# PLANNING AMENDMENT

| <b>SITE ADDRESS DETAILS</b><br>Water Lane Nursery, Low Road, Lincolnshire<br>PE12 6EF                          |                                                                                                                                                                                  |
| <b>CURRENT APPLICATION NO:</b><br>This amendment cannot be considered unless the relevant reference is stated. | H16-0689-24                                                                                                                                                                      |

| <b>FULL DESCRIPTION OF DEVELOPMENT OF CURRENT APPLICATION THAT THIS AMENDMENT RELATES TO</b>                                                                                             | Demolition of existing agricultural barns and greenhouse and erection of residential development. |                   |

DRAWING NUMBER 594.PD1.01

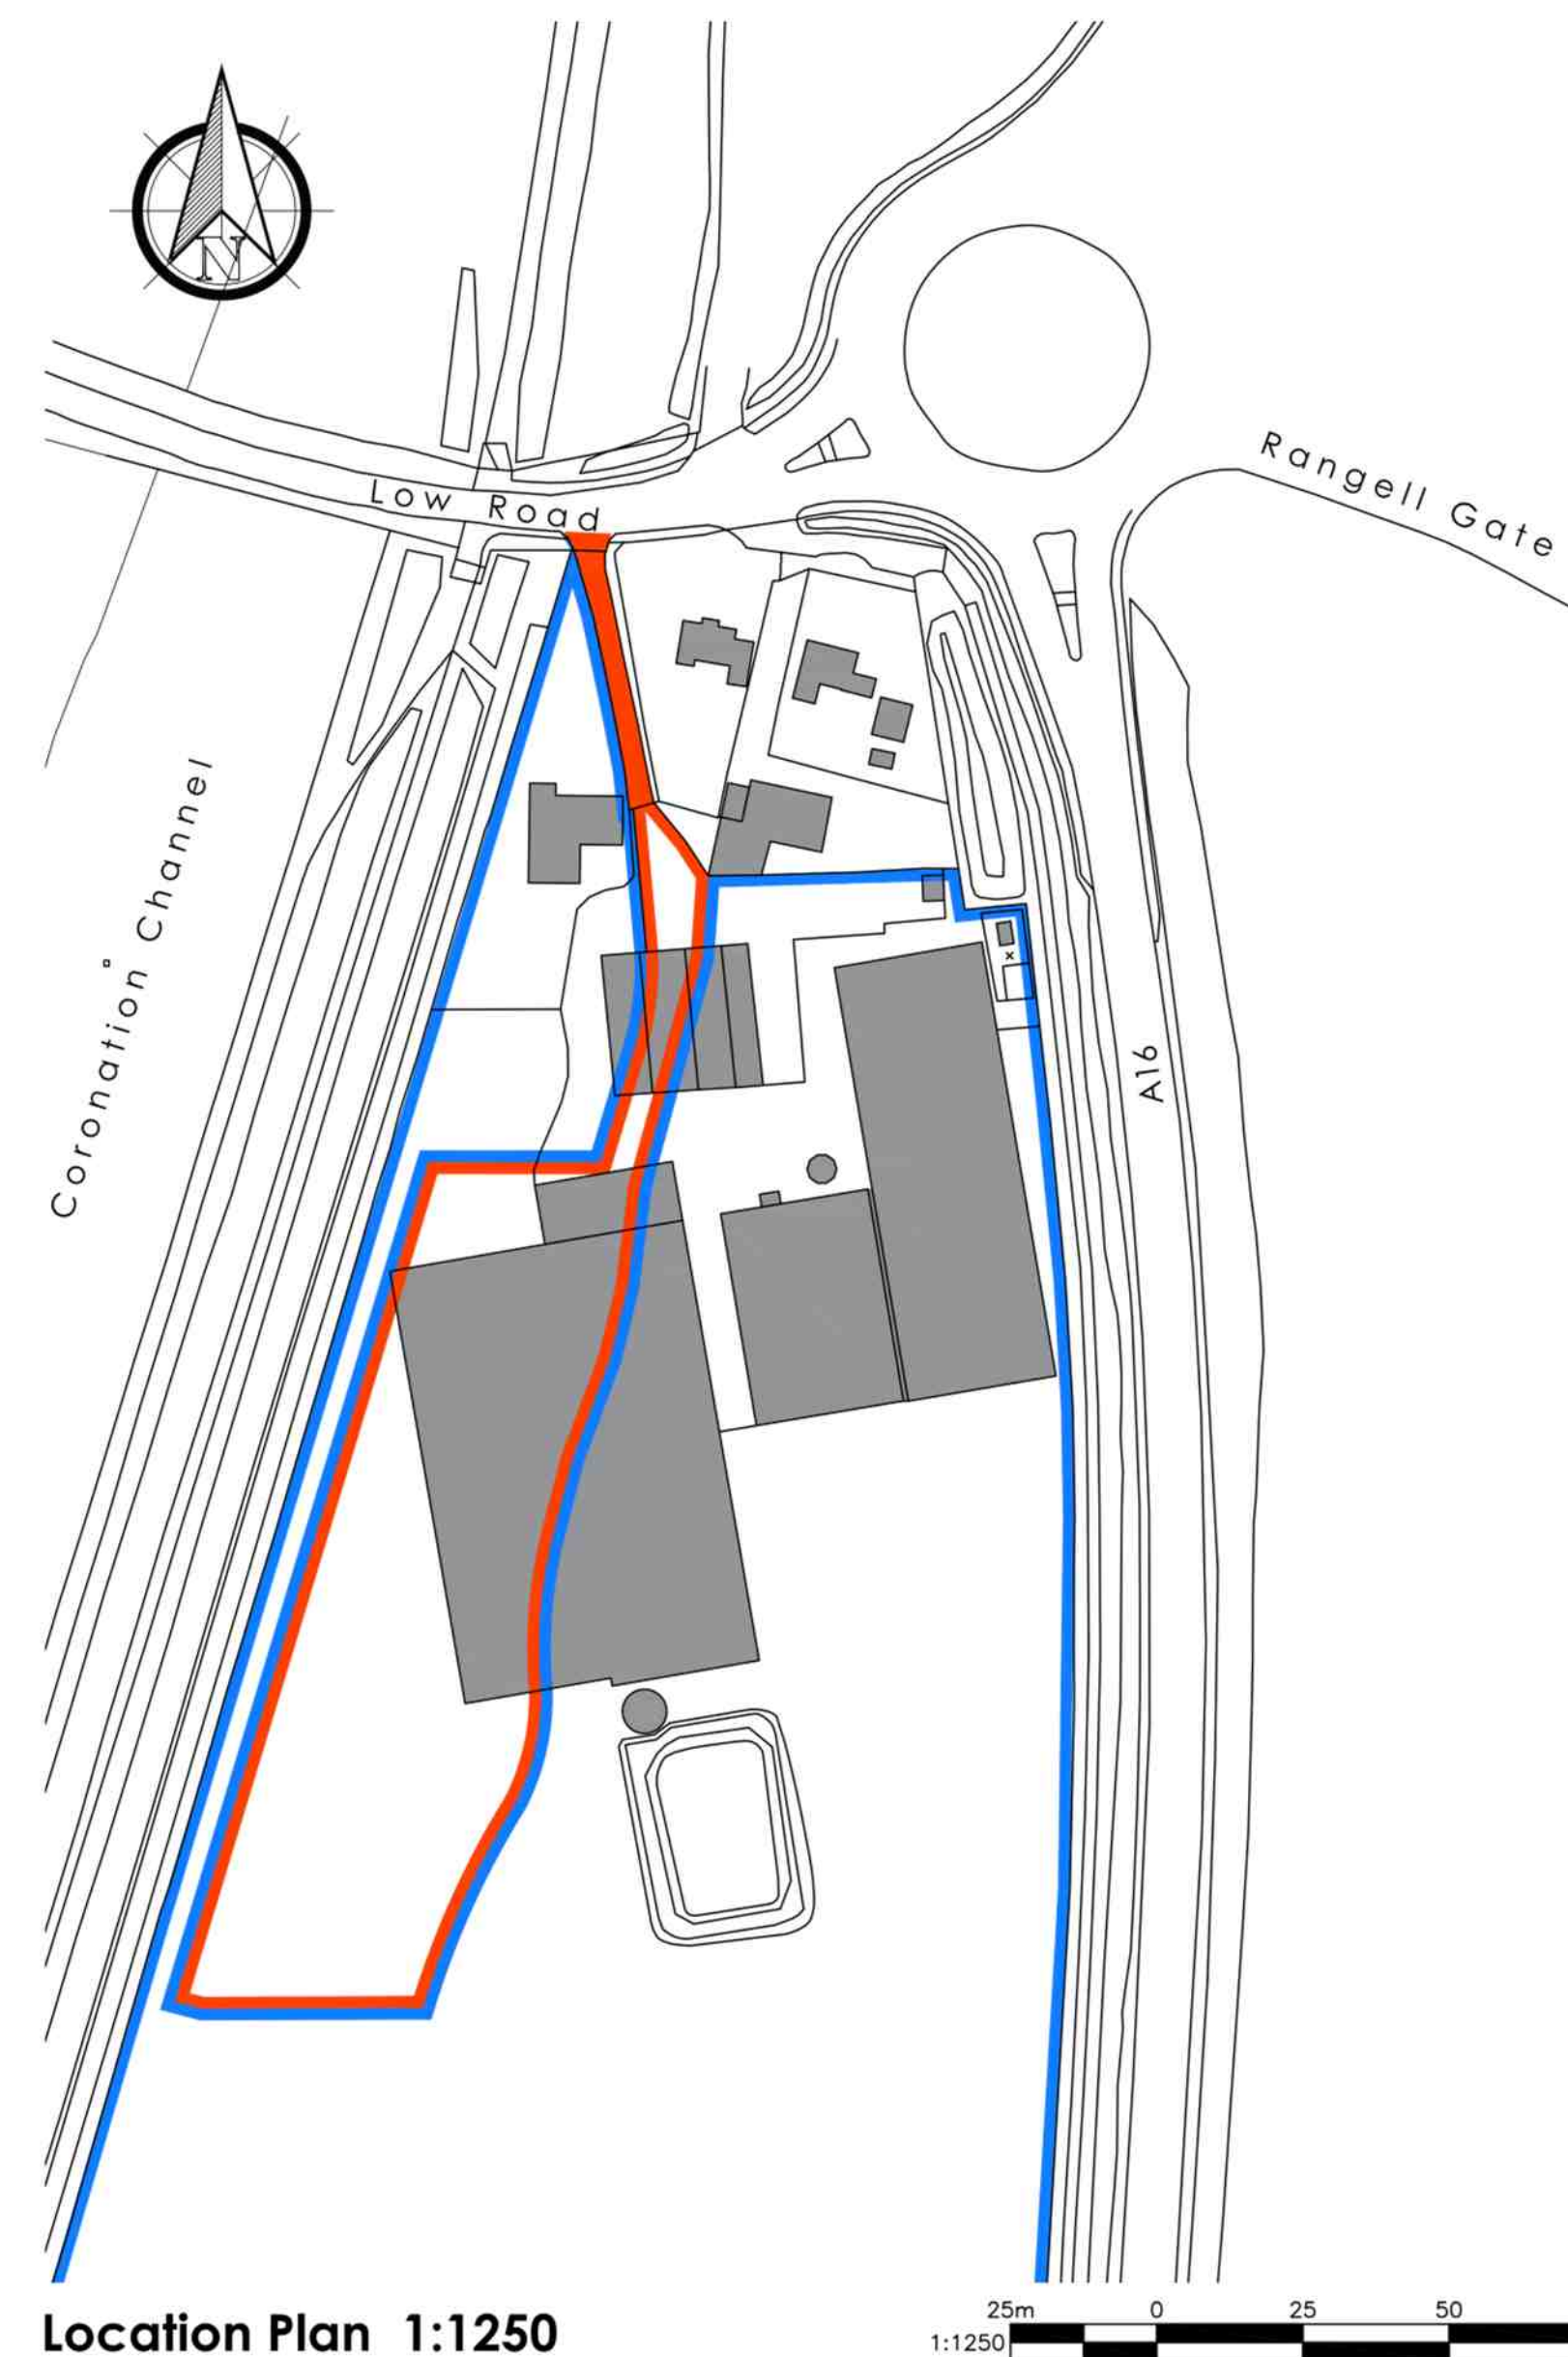
| State details of amendments proposed. (Give a full detailed list of the changes; and also mark these clearly on the accompanying plans. Only the changes listed here will be considered) | Amended red and blue line on Site Layout and Location Plan drawing                                |                   |
| Has this amendment been requested by the Council? (If so, state Officer dealing with the application)                                                                                    | YES/NO                                                                                            | Yes - Mark Niland |

| Describe any part of the original development which is excluded by virtue of the amendment, and state any alteration to plot numbers                                                     | 594.PD1.01 - Site Layout and Location Plan_F                                                      |                   |
